SHD0014/22 Junction of Santry Avenue & Swords Road, Santry, Dublin 9.

Comments by DCC Parks, Biodiversity & Landscape Services

August 19th 2022

Layout ID: D1809.P04	Scale: AS SHOWN
		Project: Santry Avenue SHD, Santry, Dublin 9	Job No: D1809
		Drawing Name: Site Layout - Taking in Charge	Series: Planning
			Date: 19/07/2021
		Status: Planning

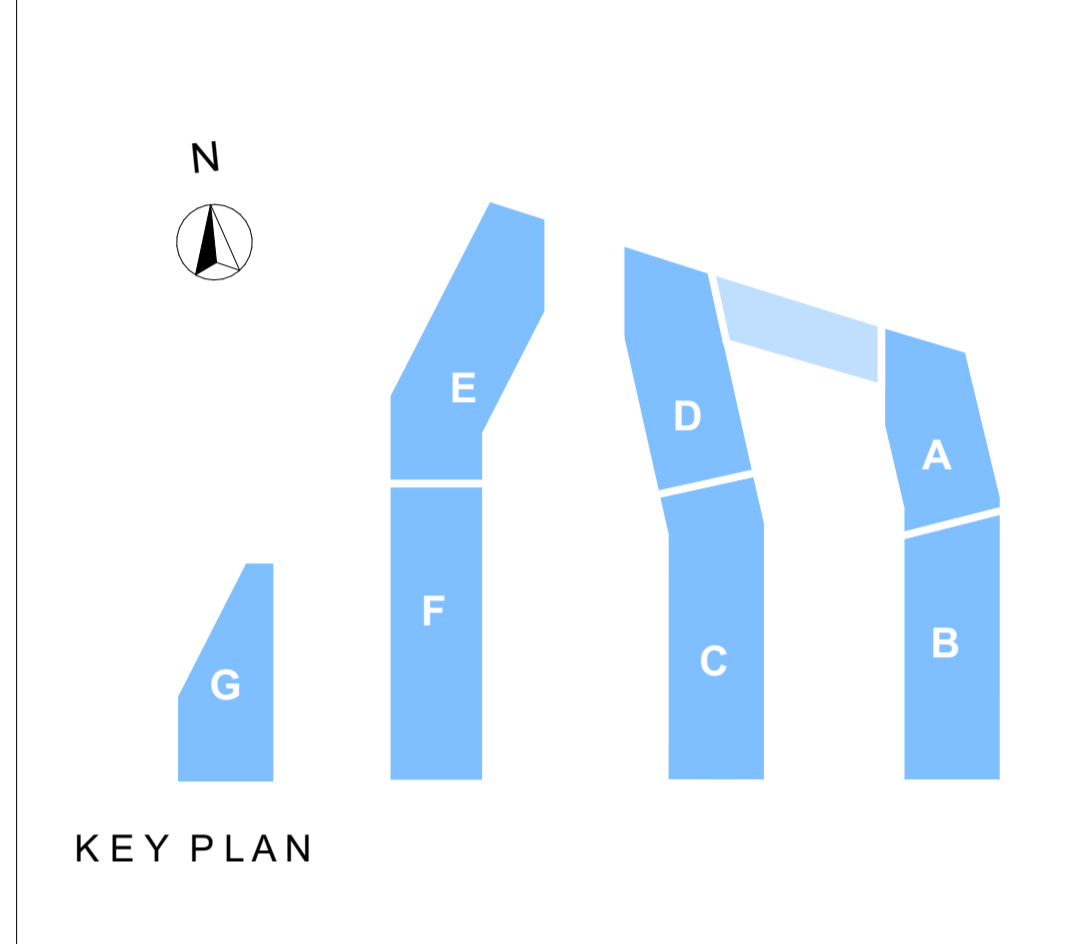
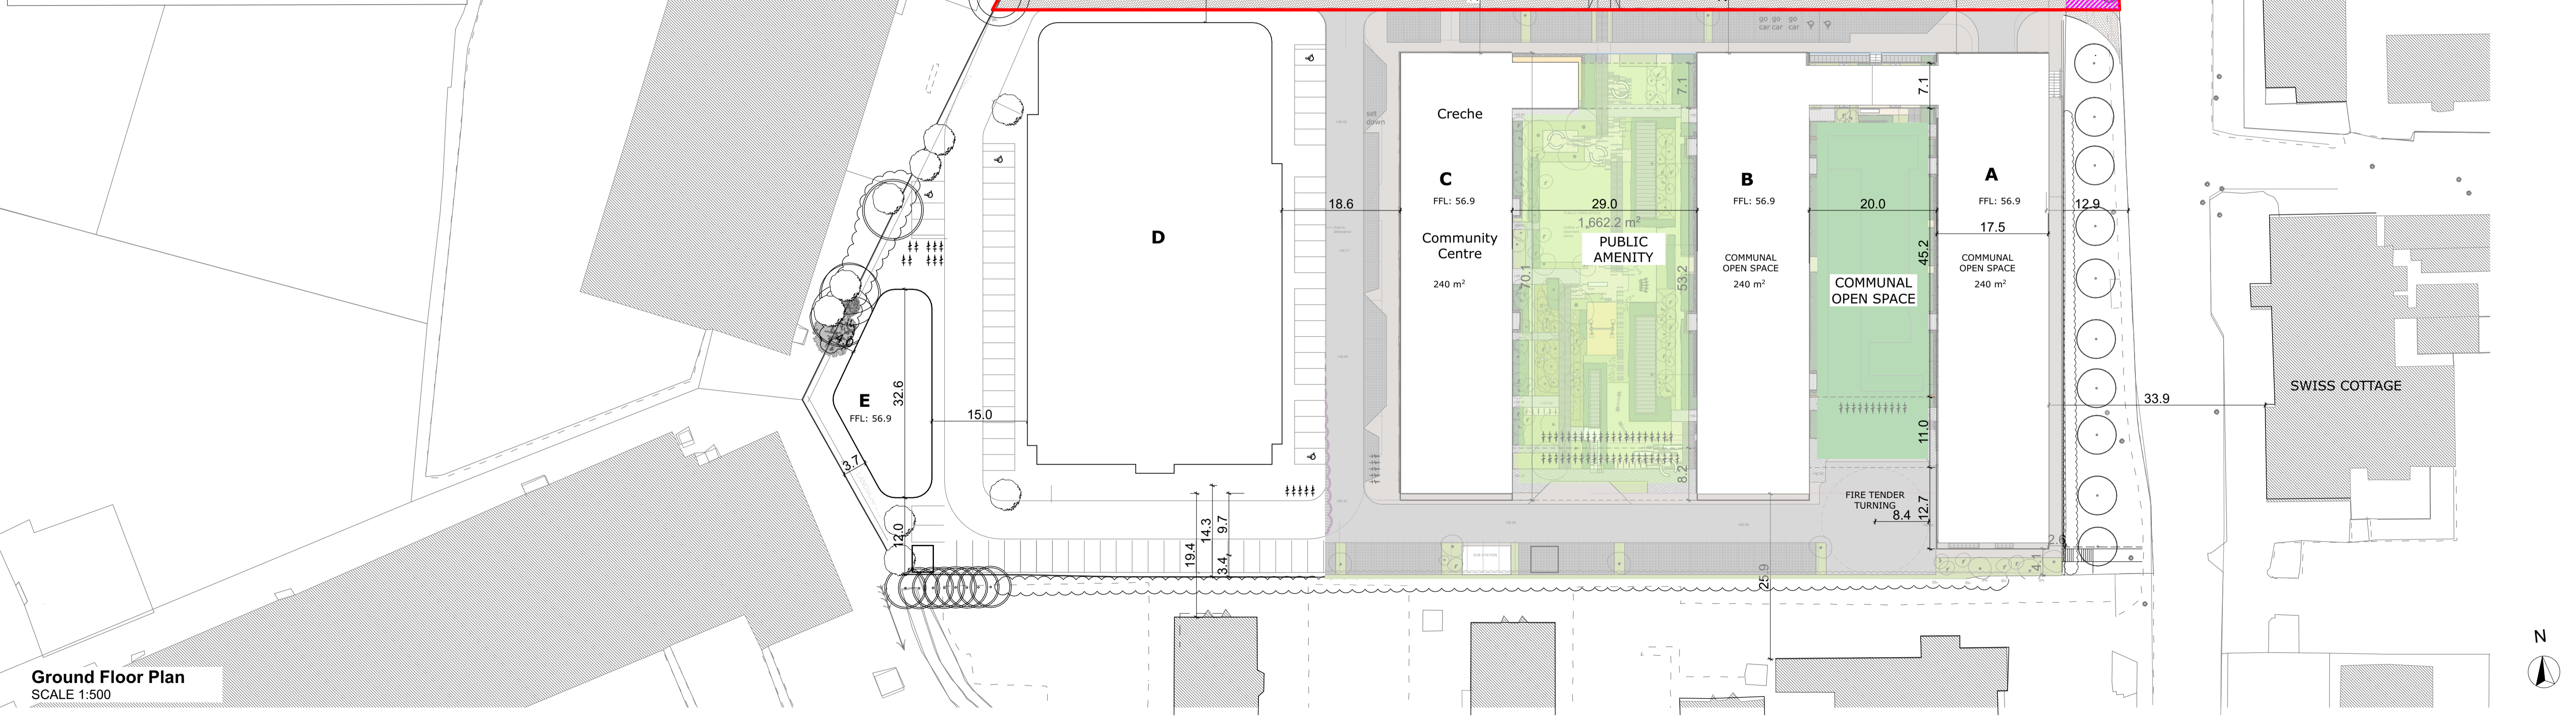
The proposed public open space will not be taken in charge and conditions safeguarding future public access and use are advised for any grant of planning permission.

The proposed public open space diagram (below) indicates public open space (1915m²) measured up to the buildings facades. This is not an acceptable approach as a buffer strip of communal /private open space is required for all ground level apartments. The calculation of the required public open space at 10% has not been suitably clarified.

The applicant/developer shall be responsible for maintenance and management of the public open spaces. The public open spaces will operate as public park/public realm in perpetuity, with public access and use operated strictly in accordance with the management regime, rules and regulations including any byelaws for public open space of the Planning Authority at all times.

Planning Drawings		Scale: 1:200, 1:1250
			Job No: D1809
Project: Santry Avenue SHD, Santry, Dublin 9	Series: Planning Drawings	Date: 17/05/2022	Status:
Drawing Name: Blocks A/B East & West Elevations	Revision:

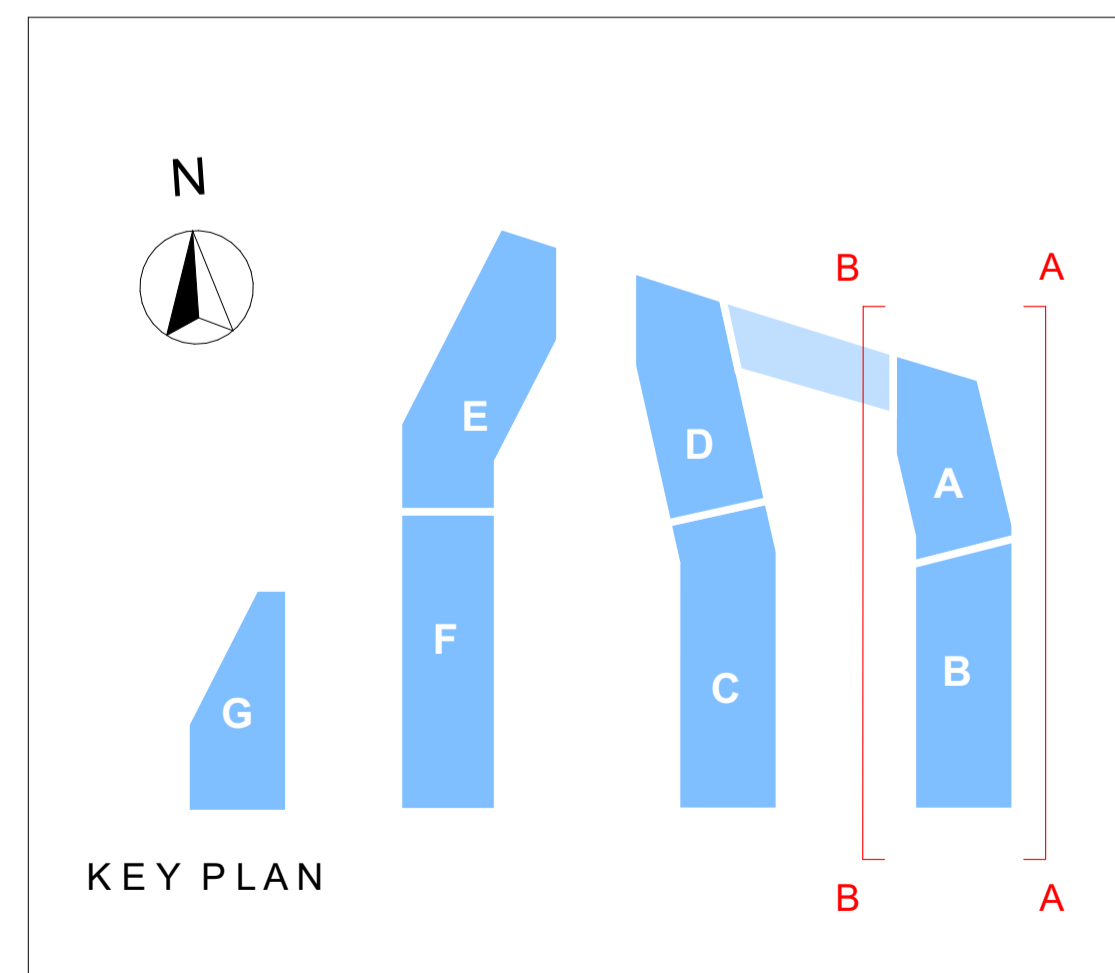
Green roofs are proposed across the proposed buildings in the scheme as per the architect's drawing D1809.P.19.

<b>Planning Drawings</b>		Layout ID: <b>D1809.P31</b>	Scale: <b>AS SHOWN</b>
			Project: <b>Santry Avenue SHD, Santry, Dublin 9</b>	Job No: <b>D1809</b>
			Drawing Name: <b>Site Layout - Phasing</b>	Series: <b>Planning</b>
				Date: <b>19/07/2021</b>
			Status: <b>Planning</b>

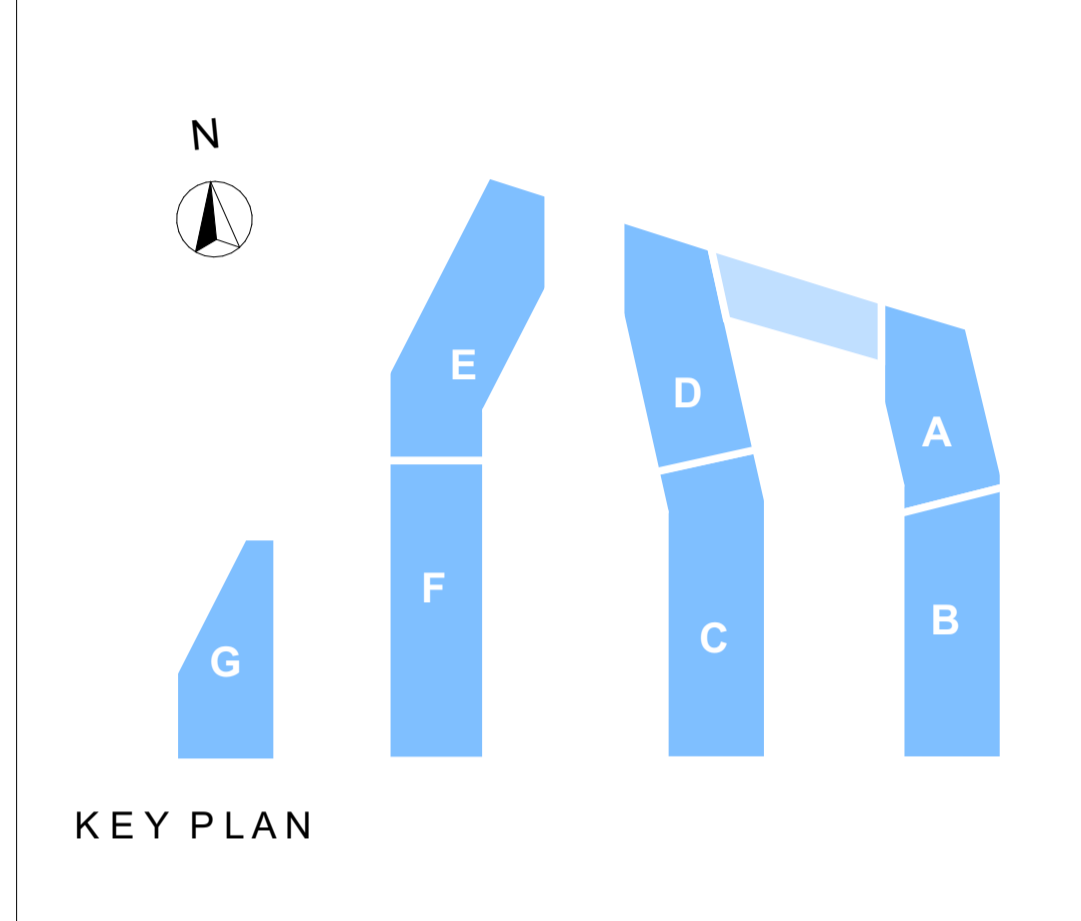
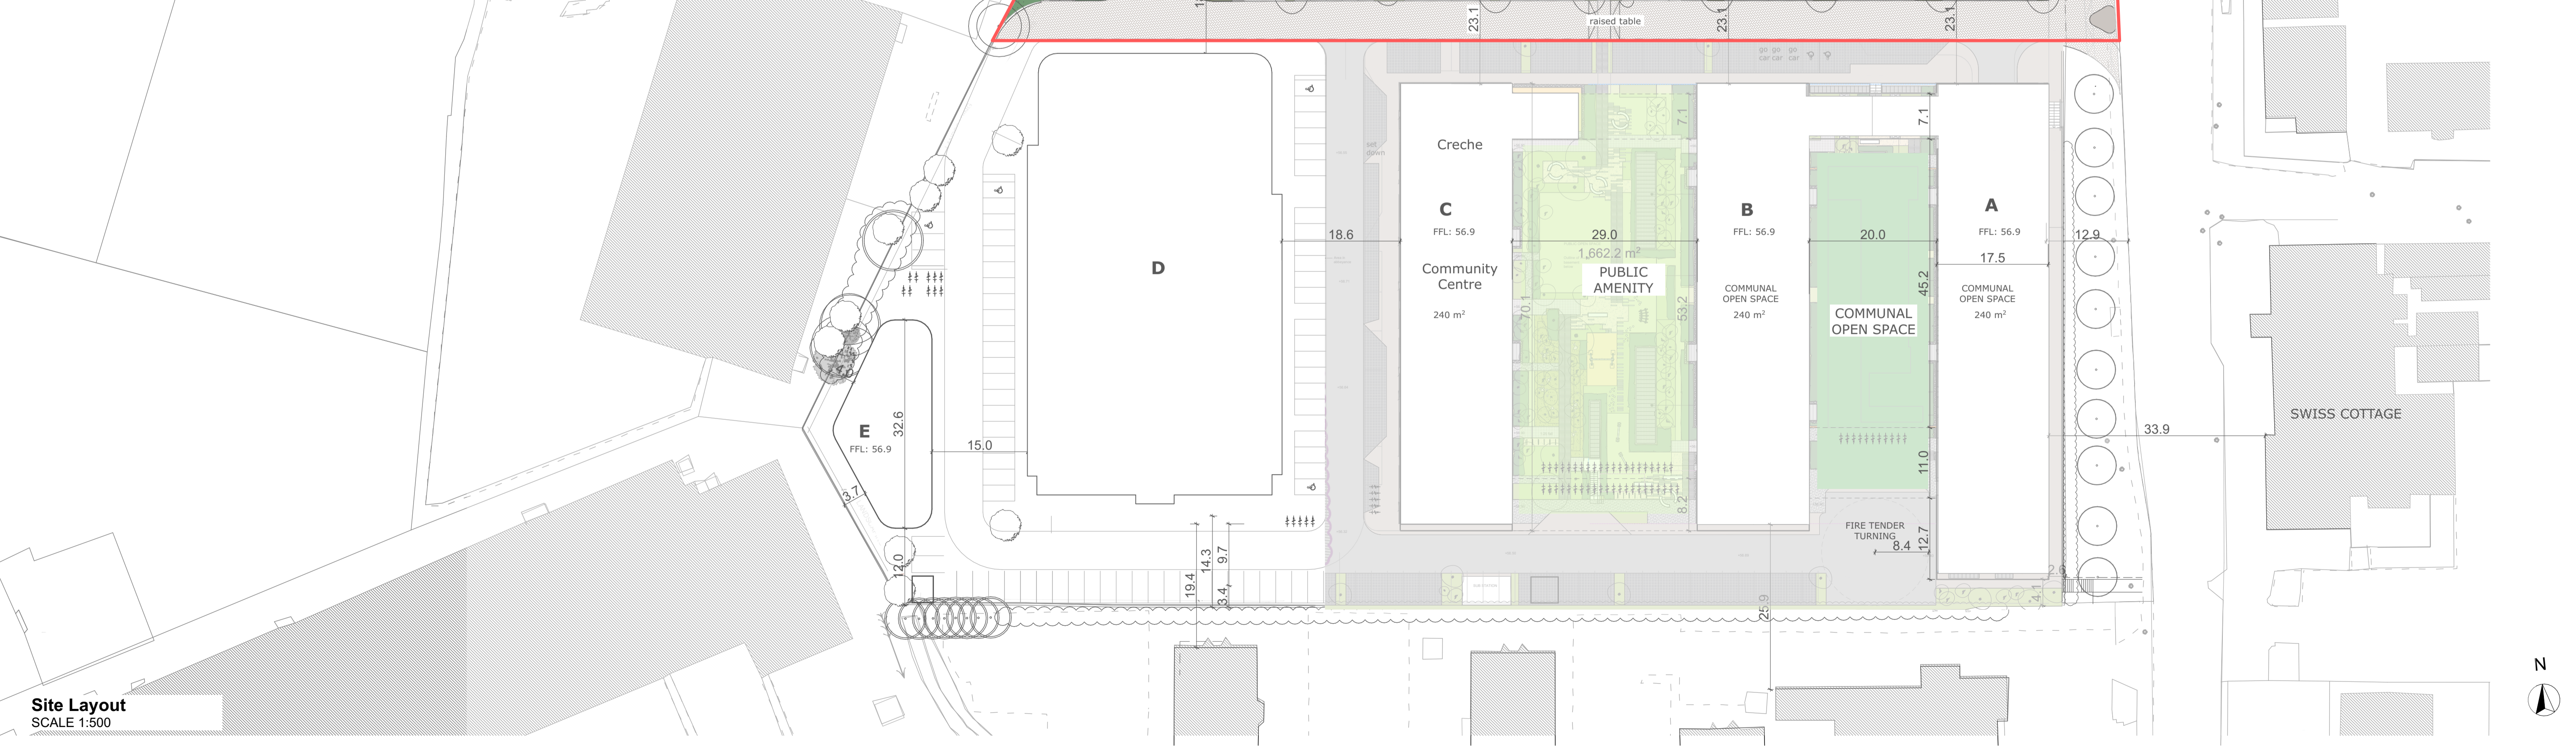
The proposed phasing plan (below) does not include areas of communal open space and public open space and this requires further clarification by conditions.
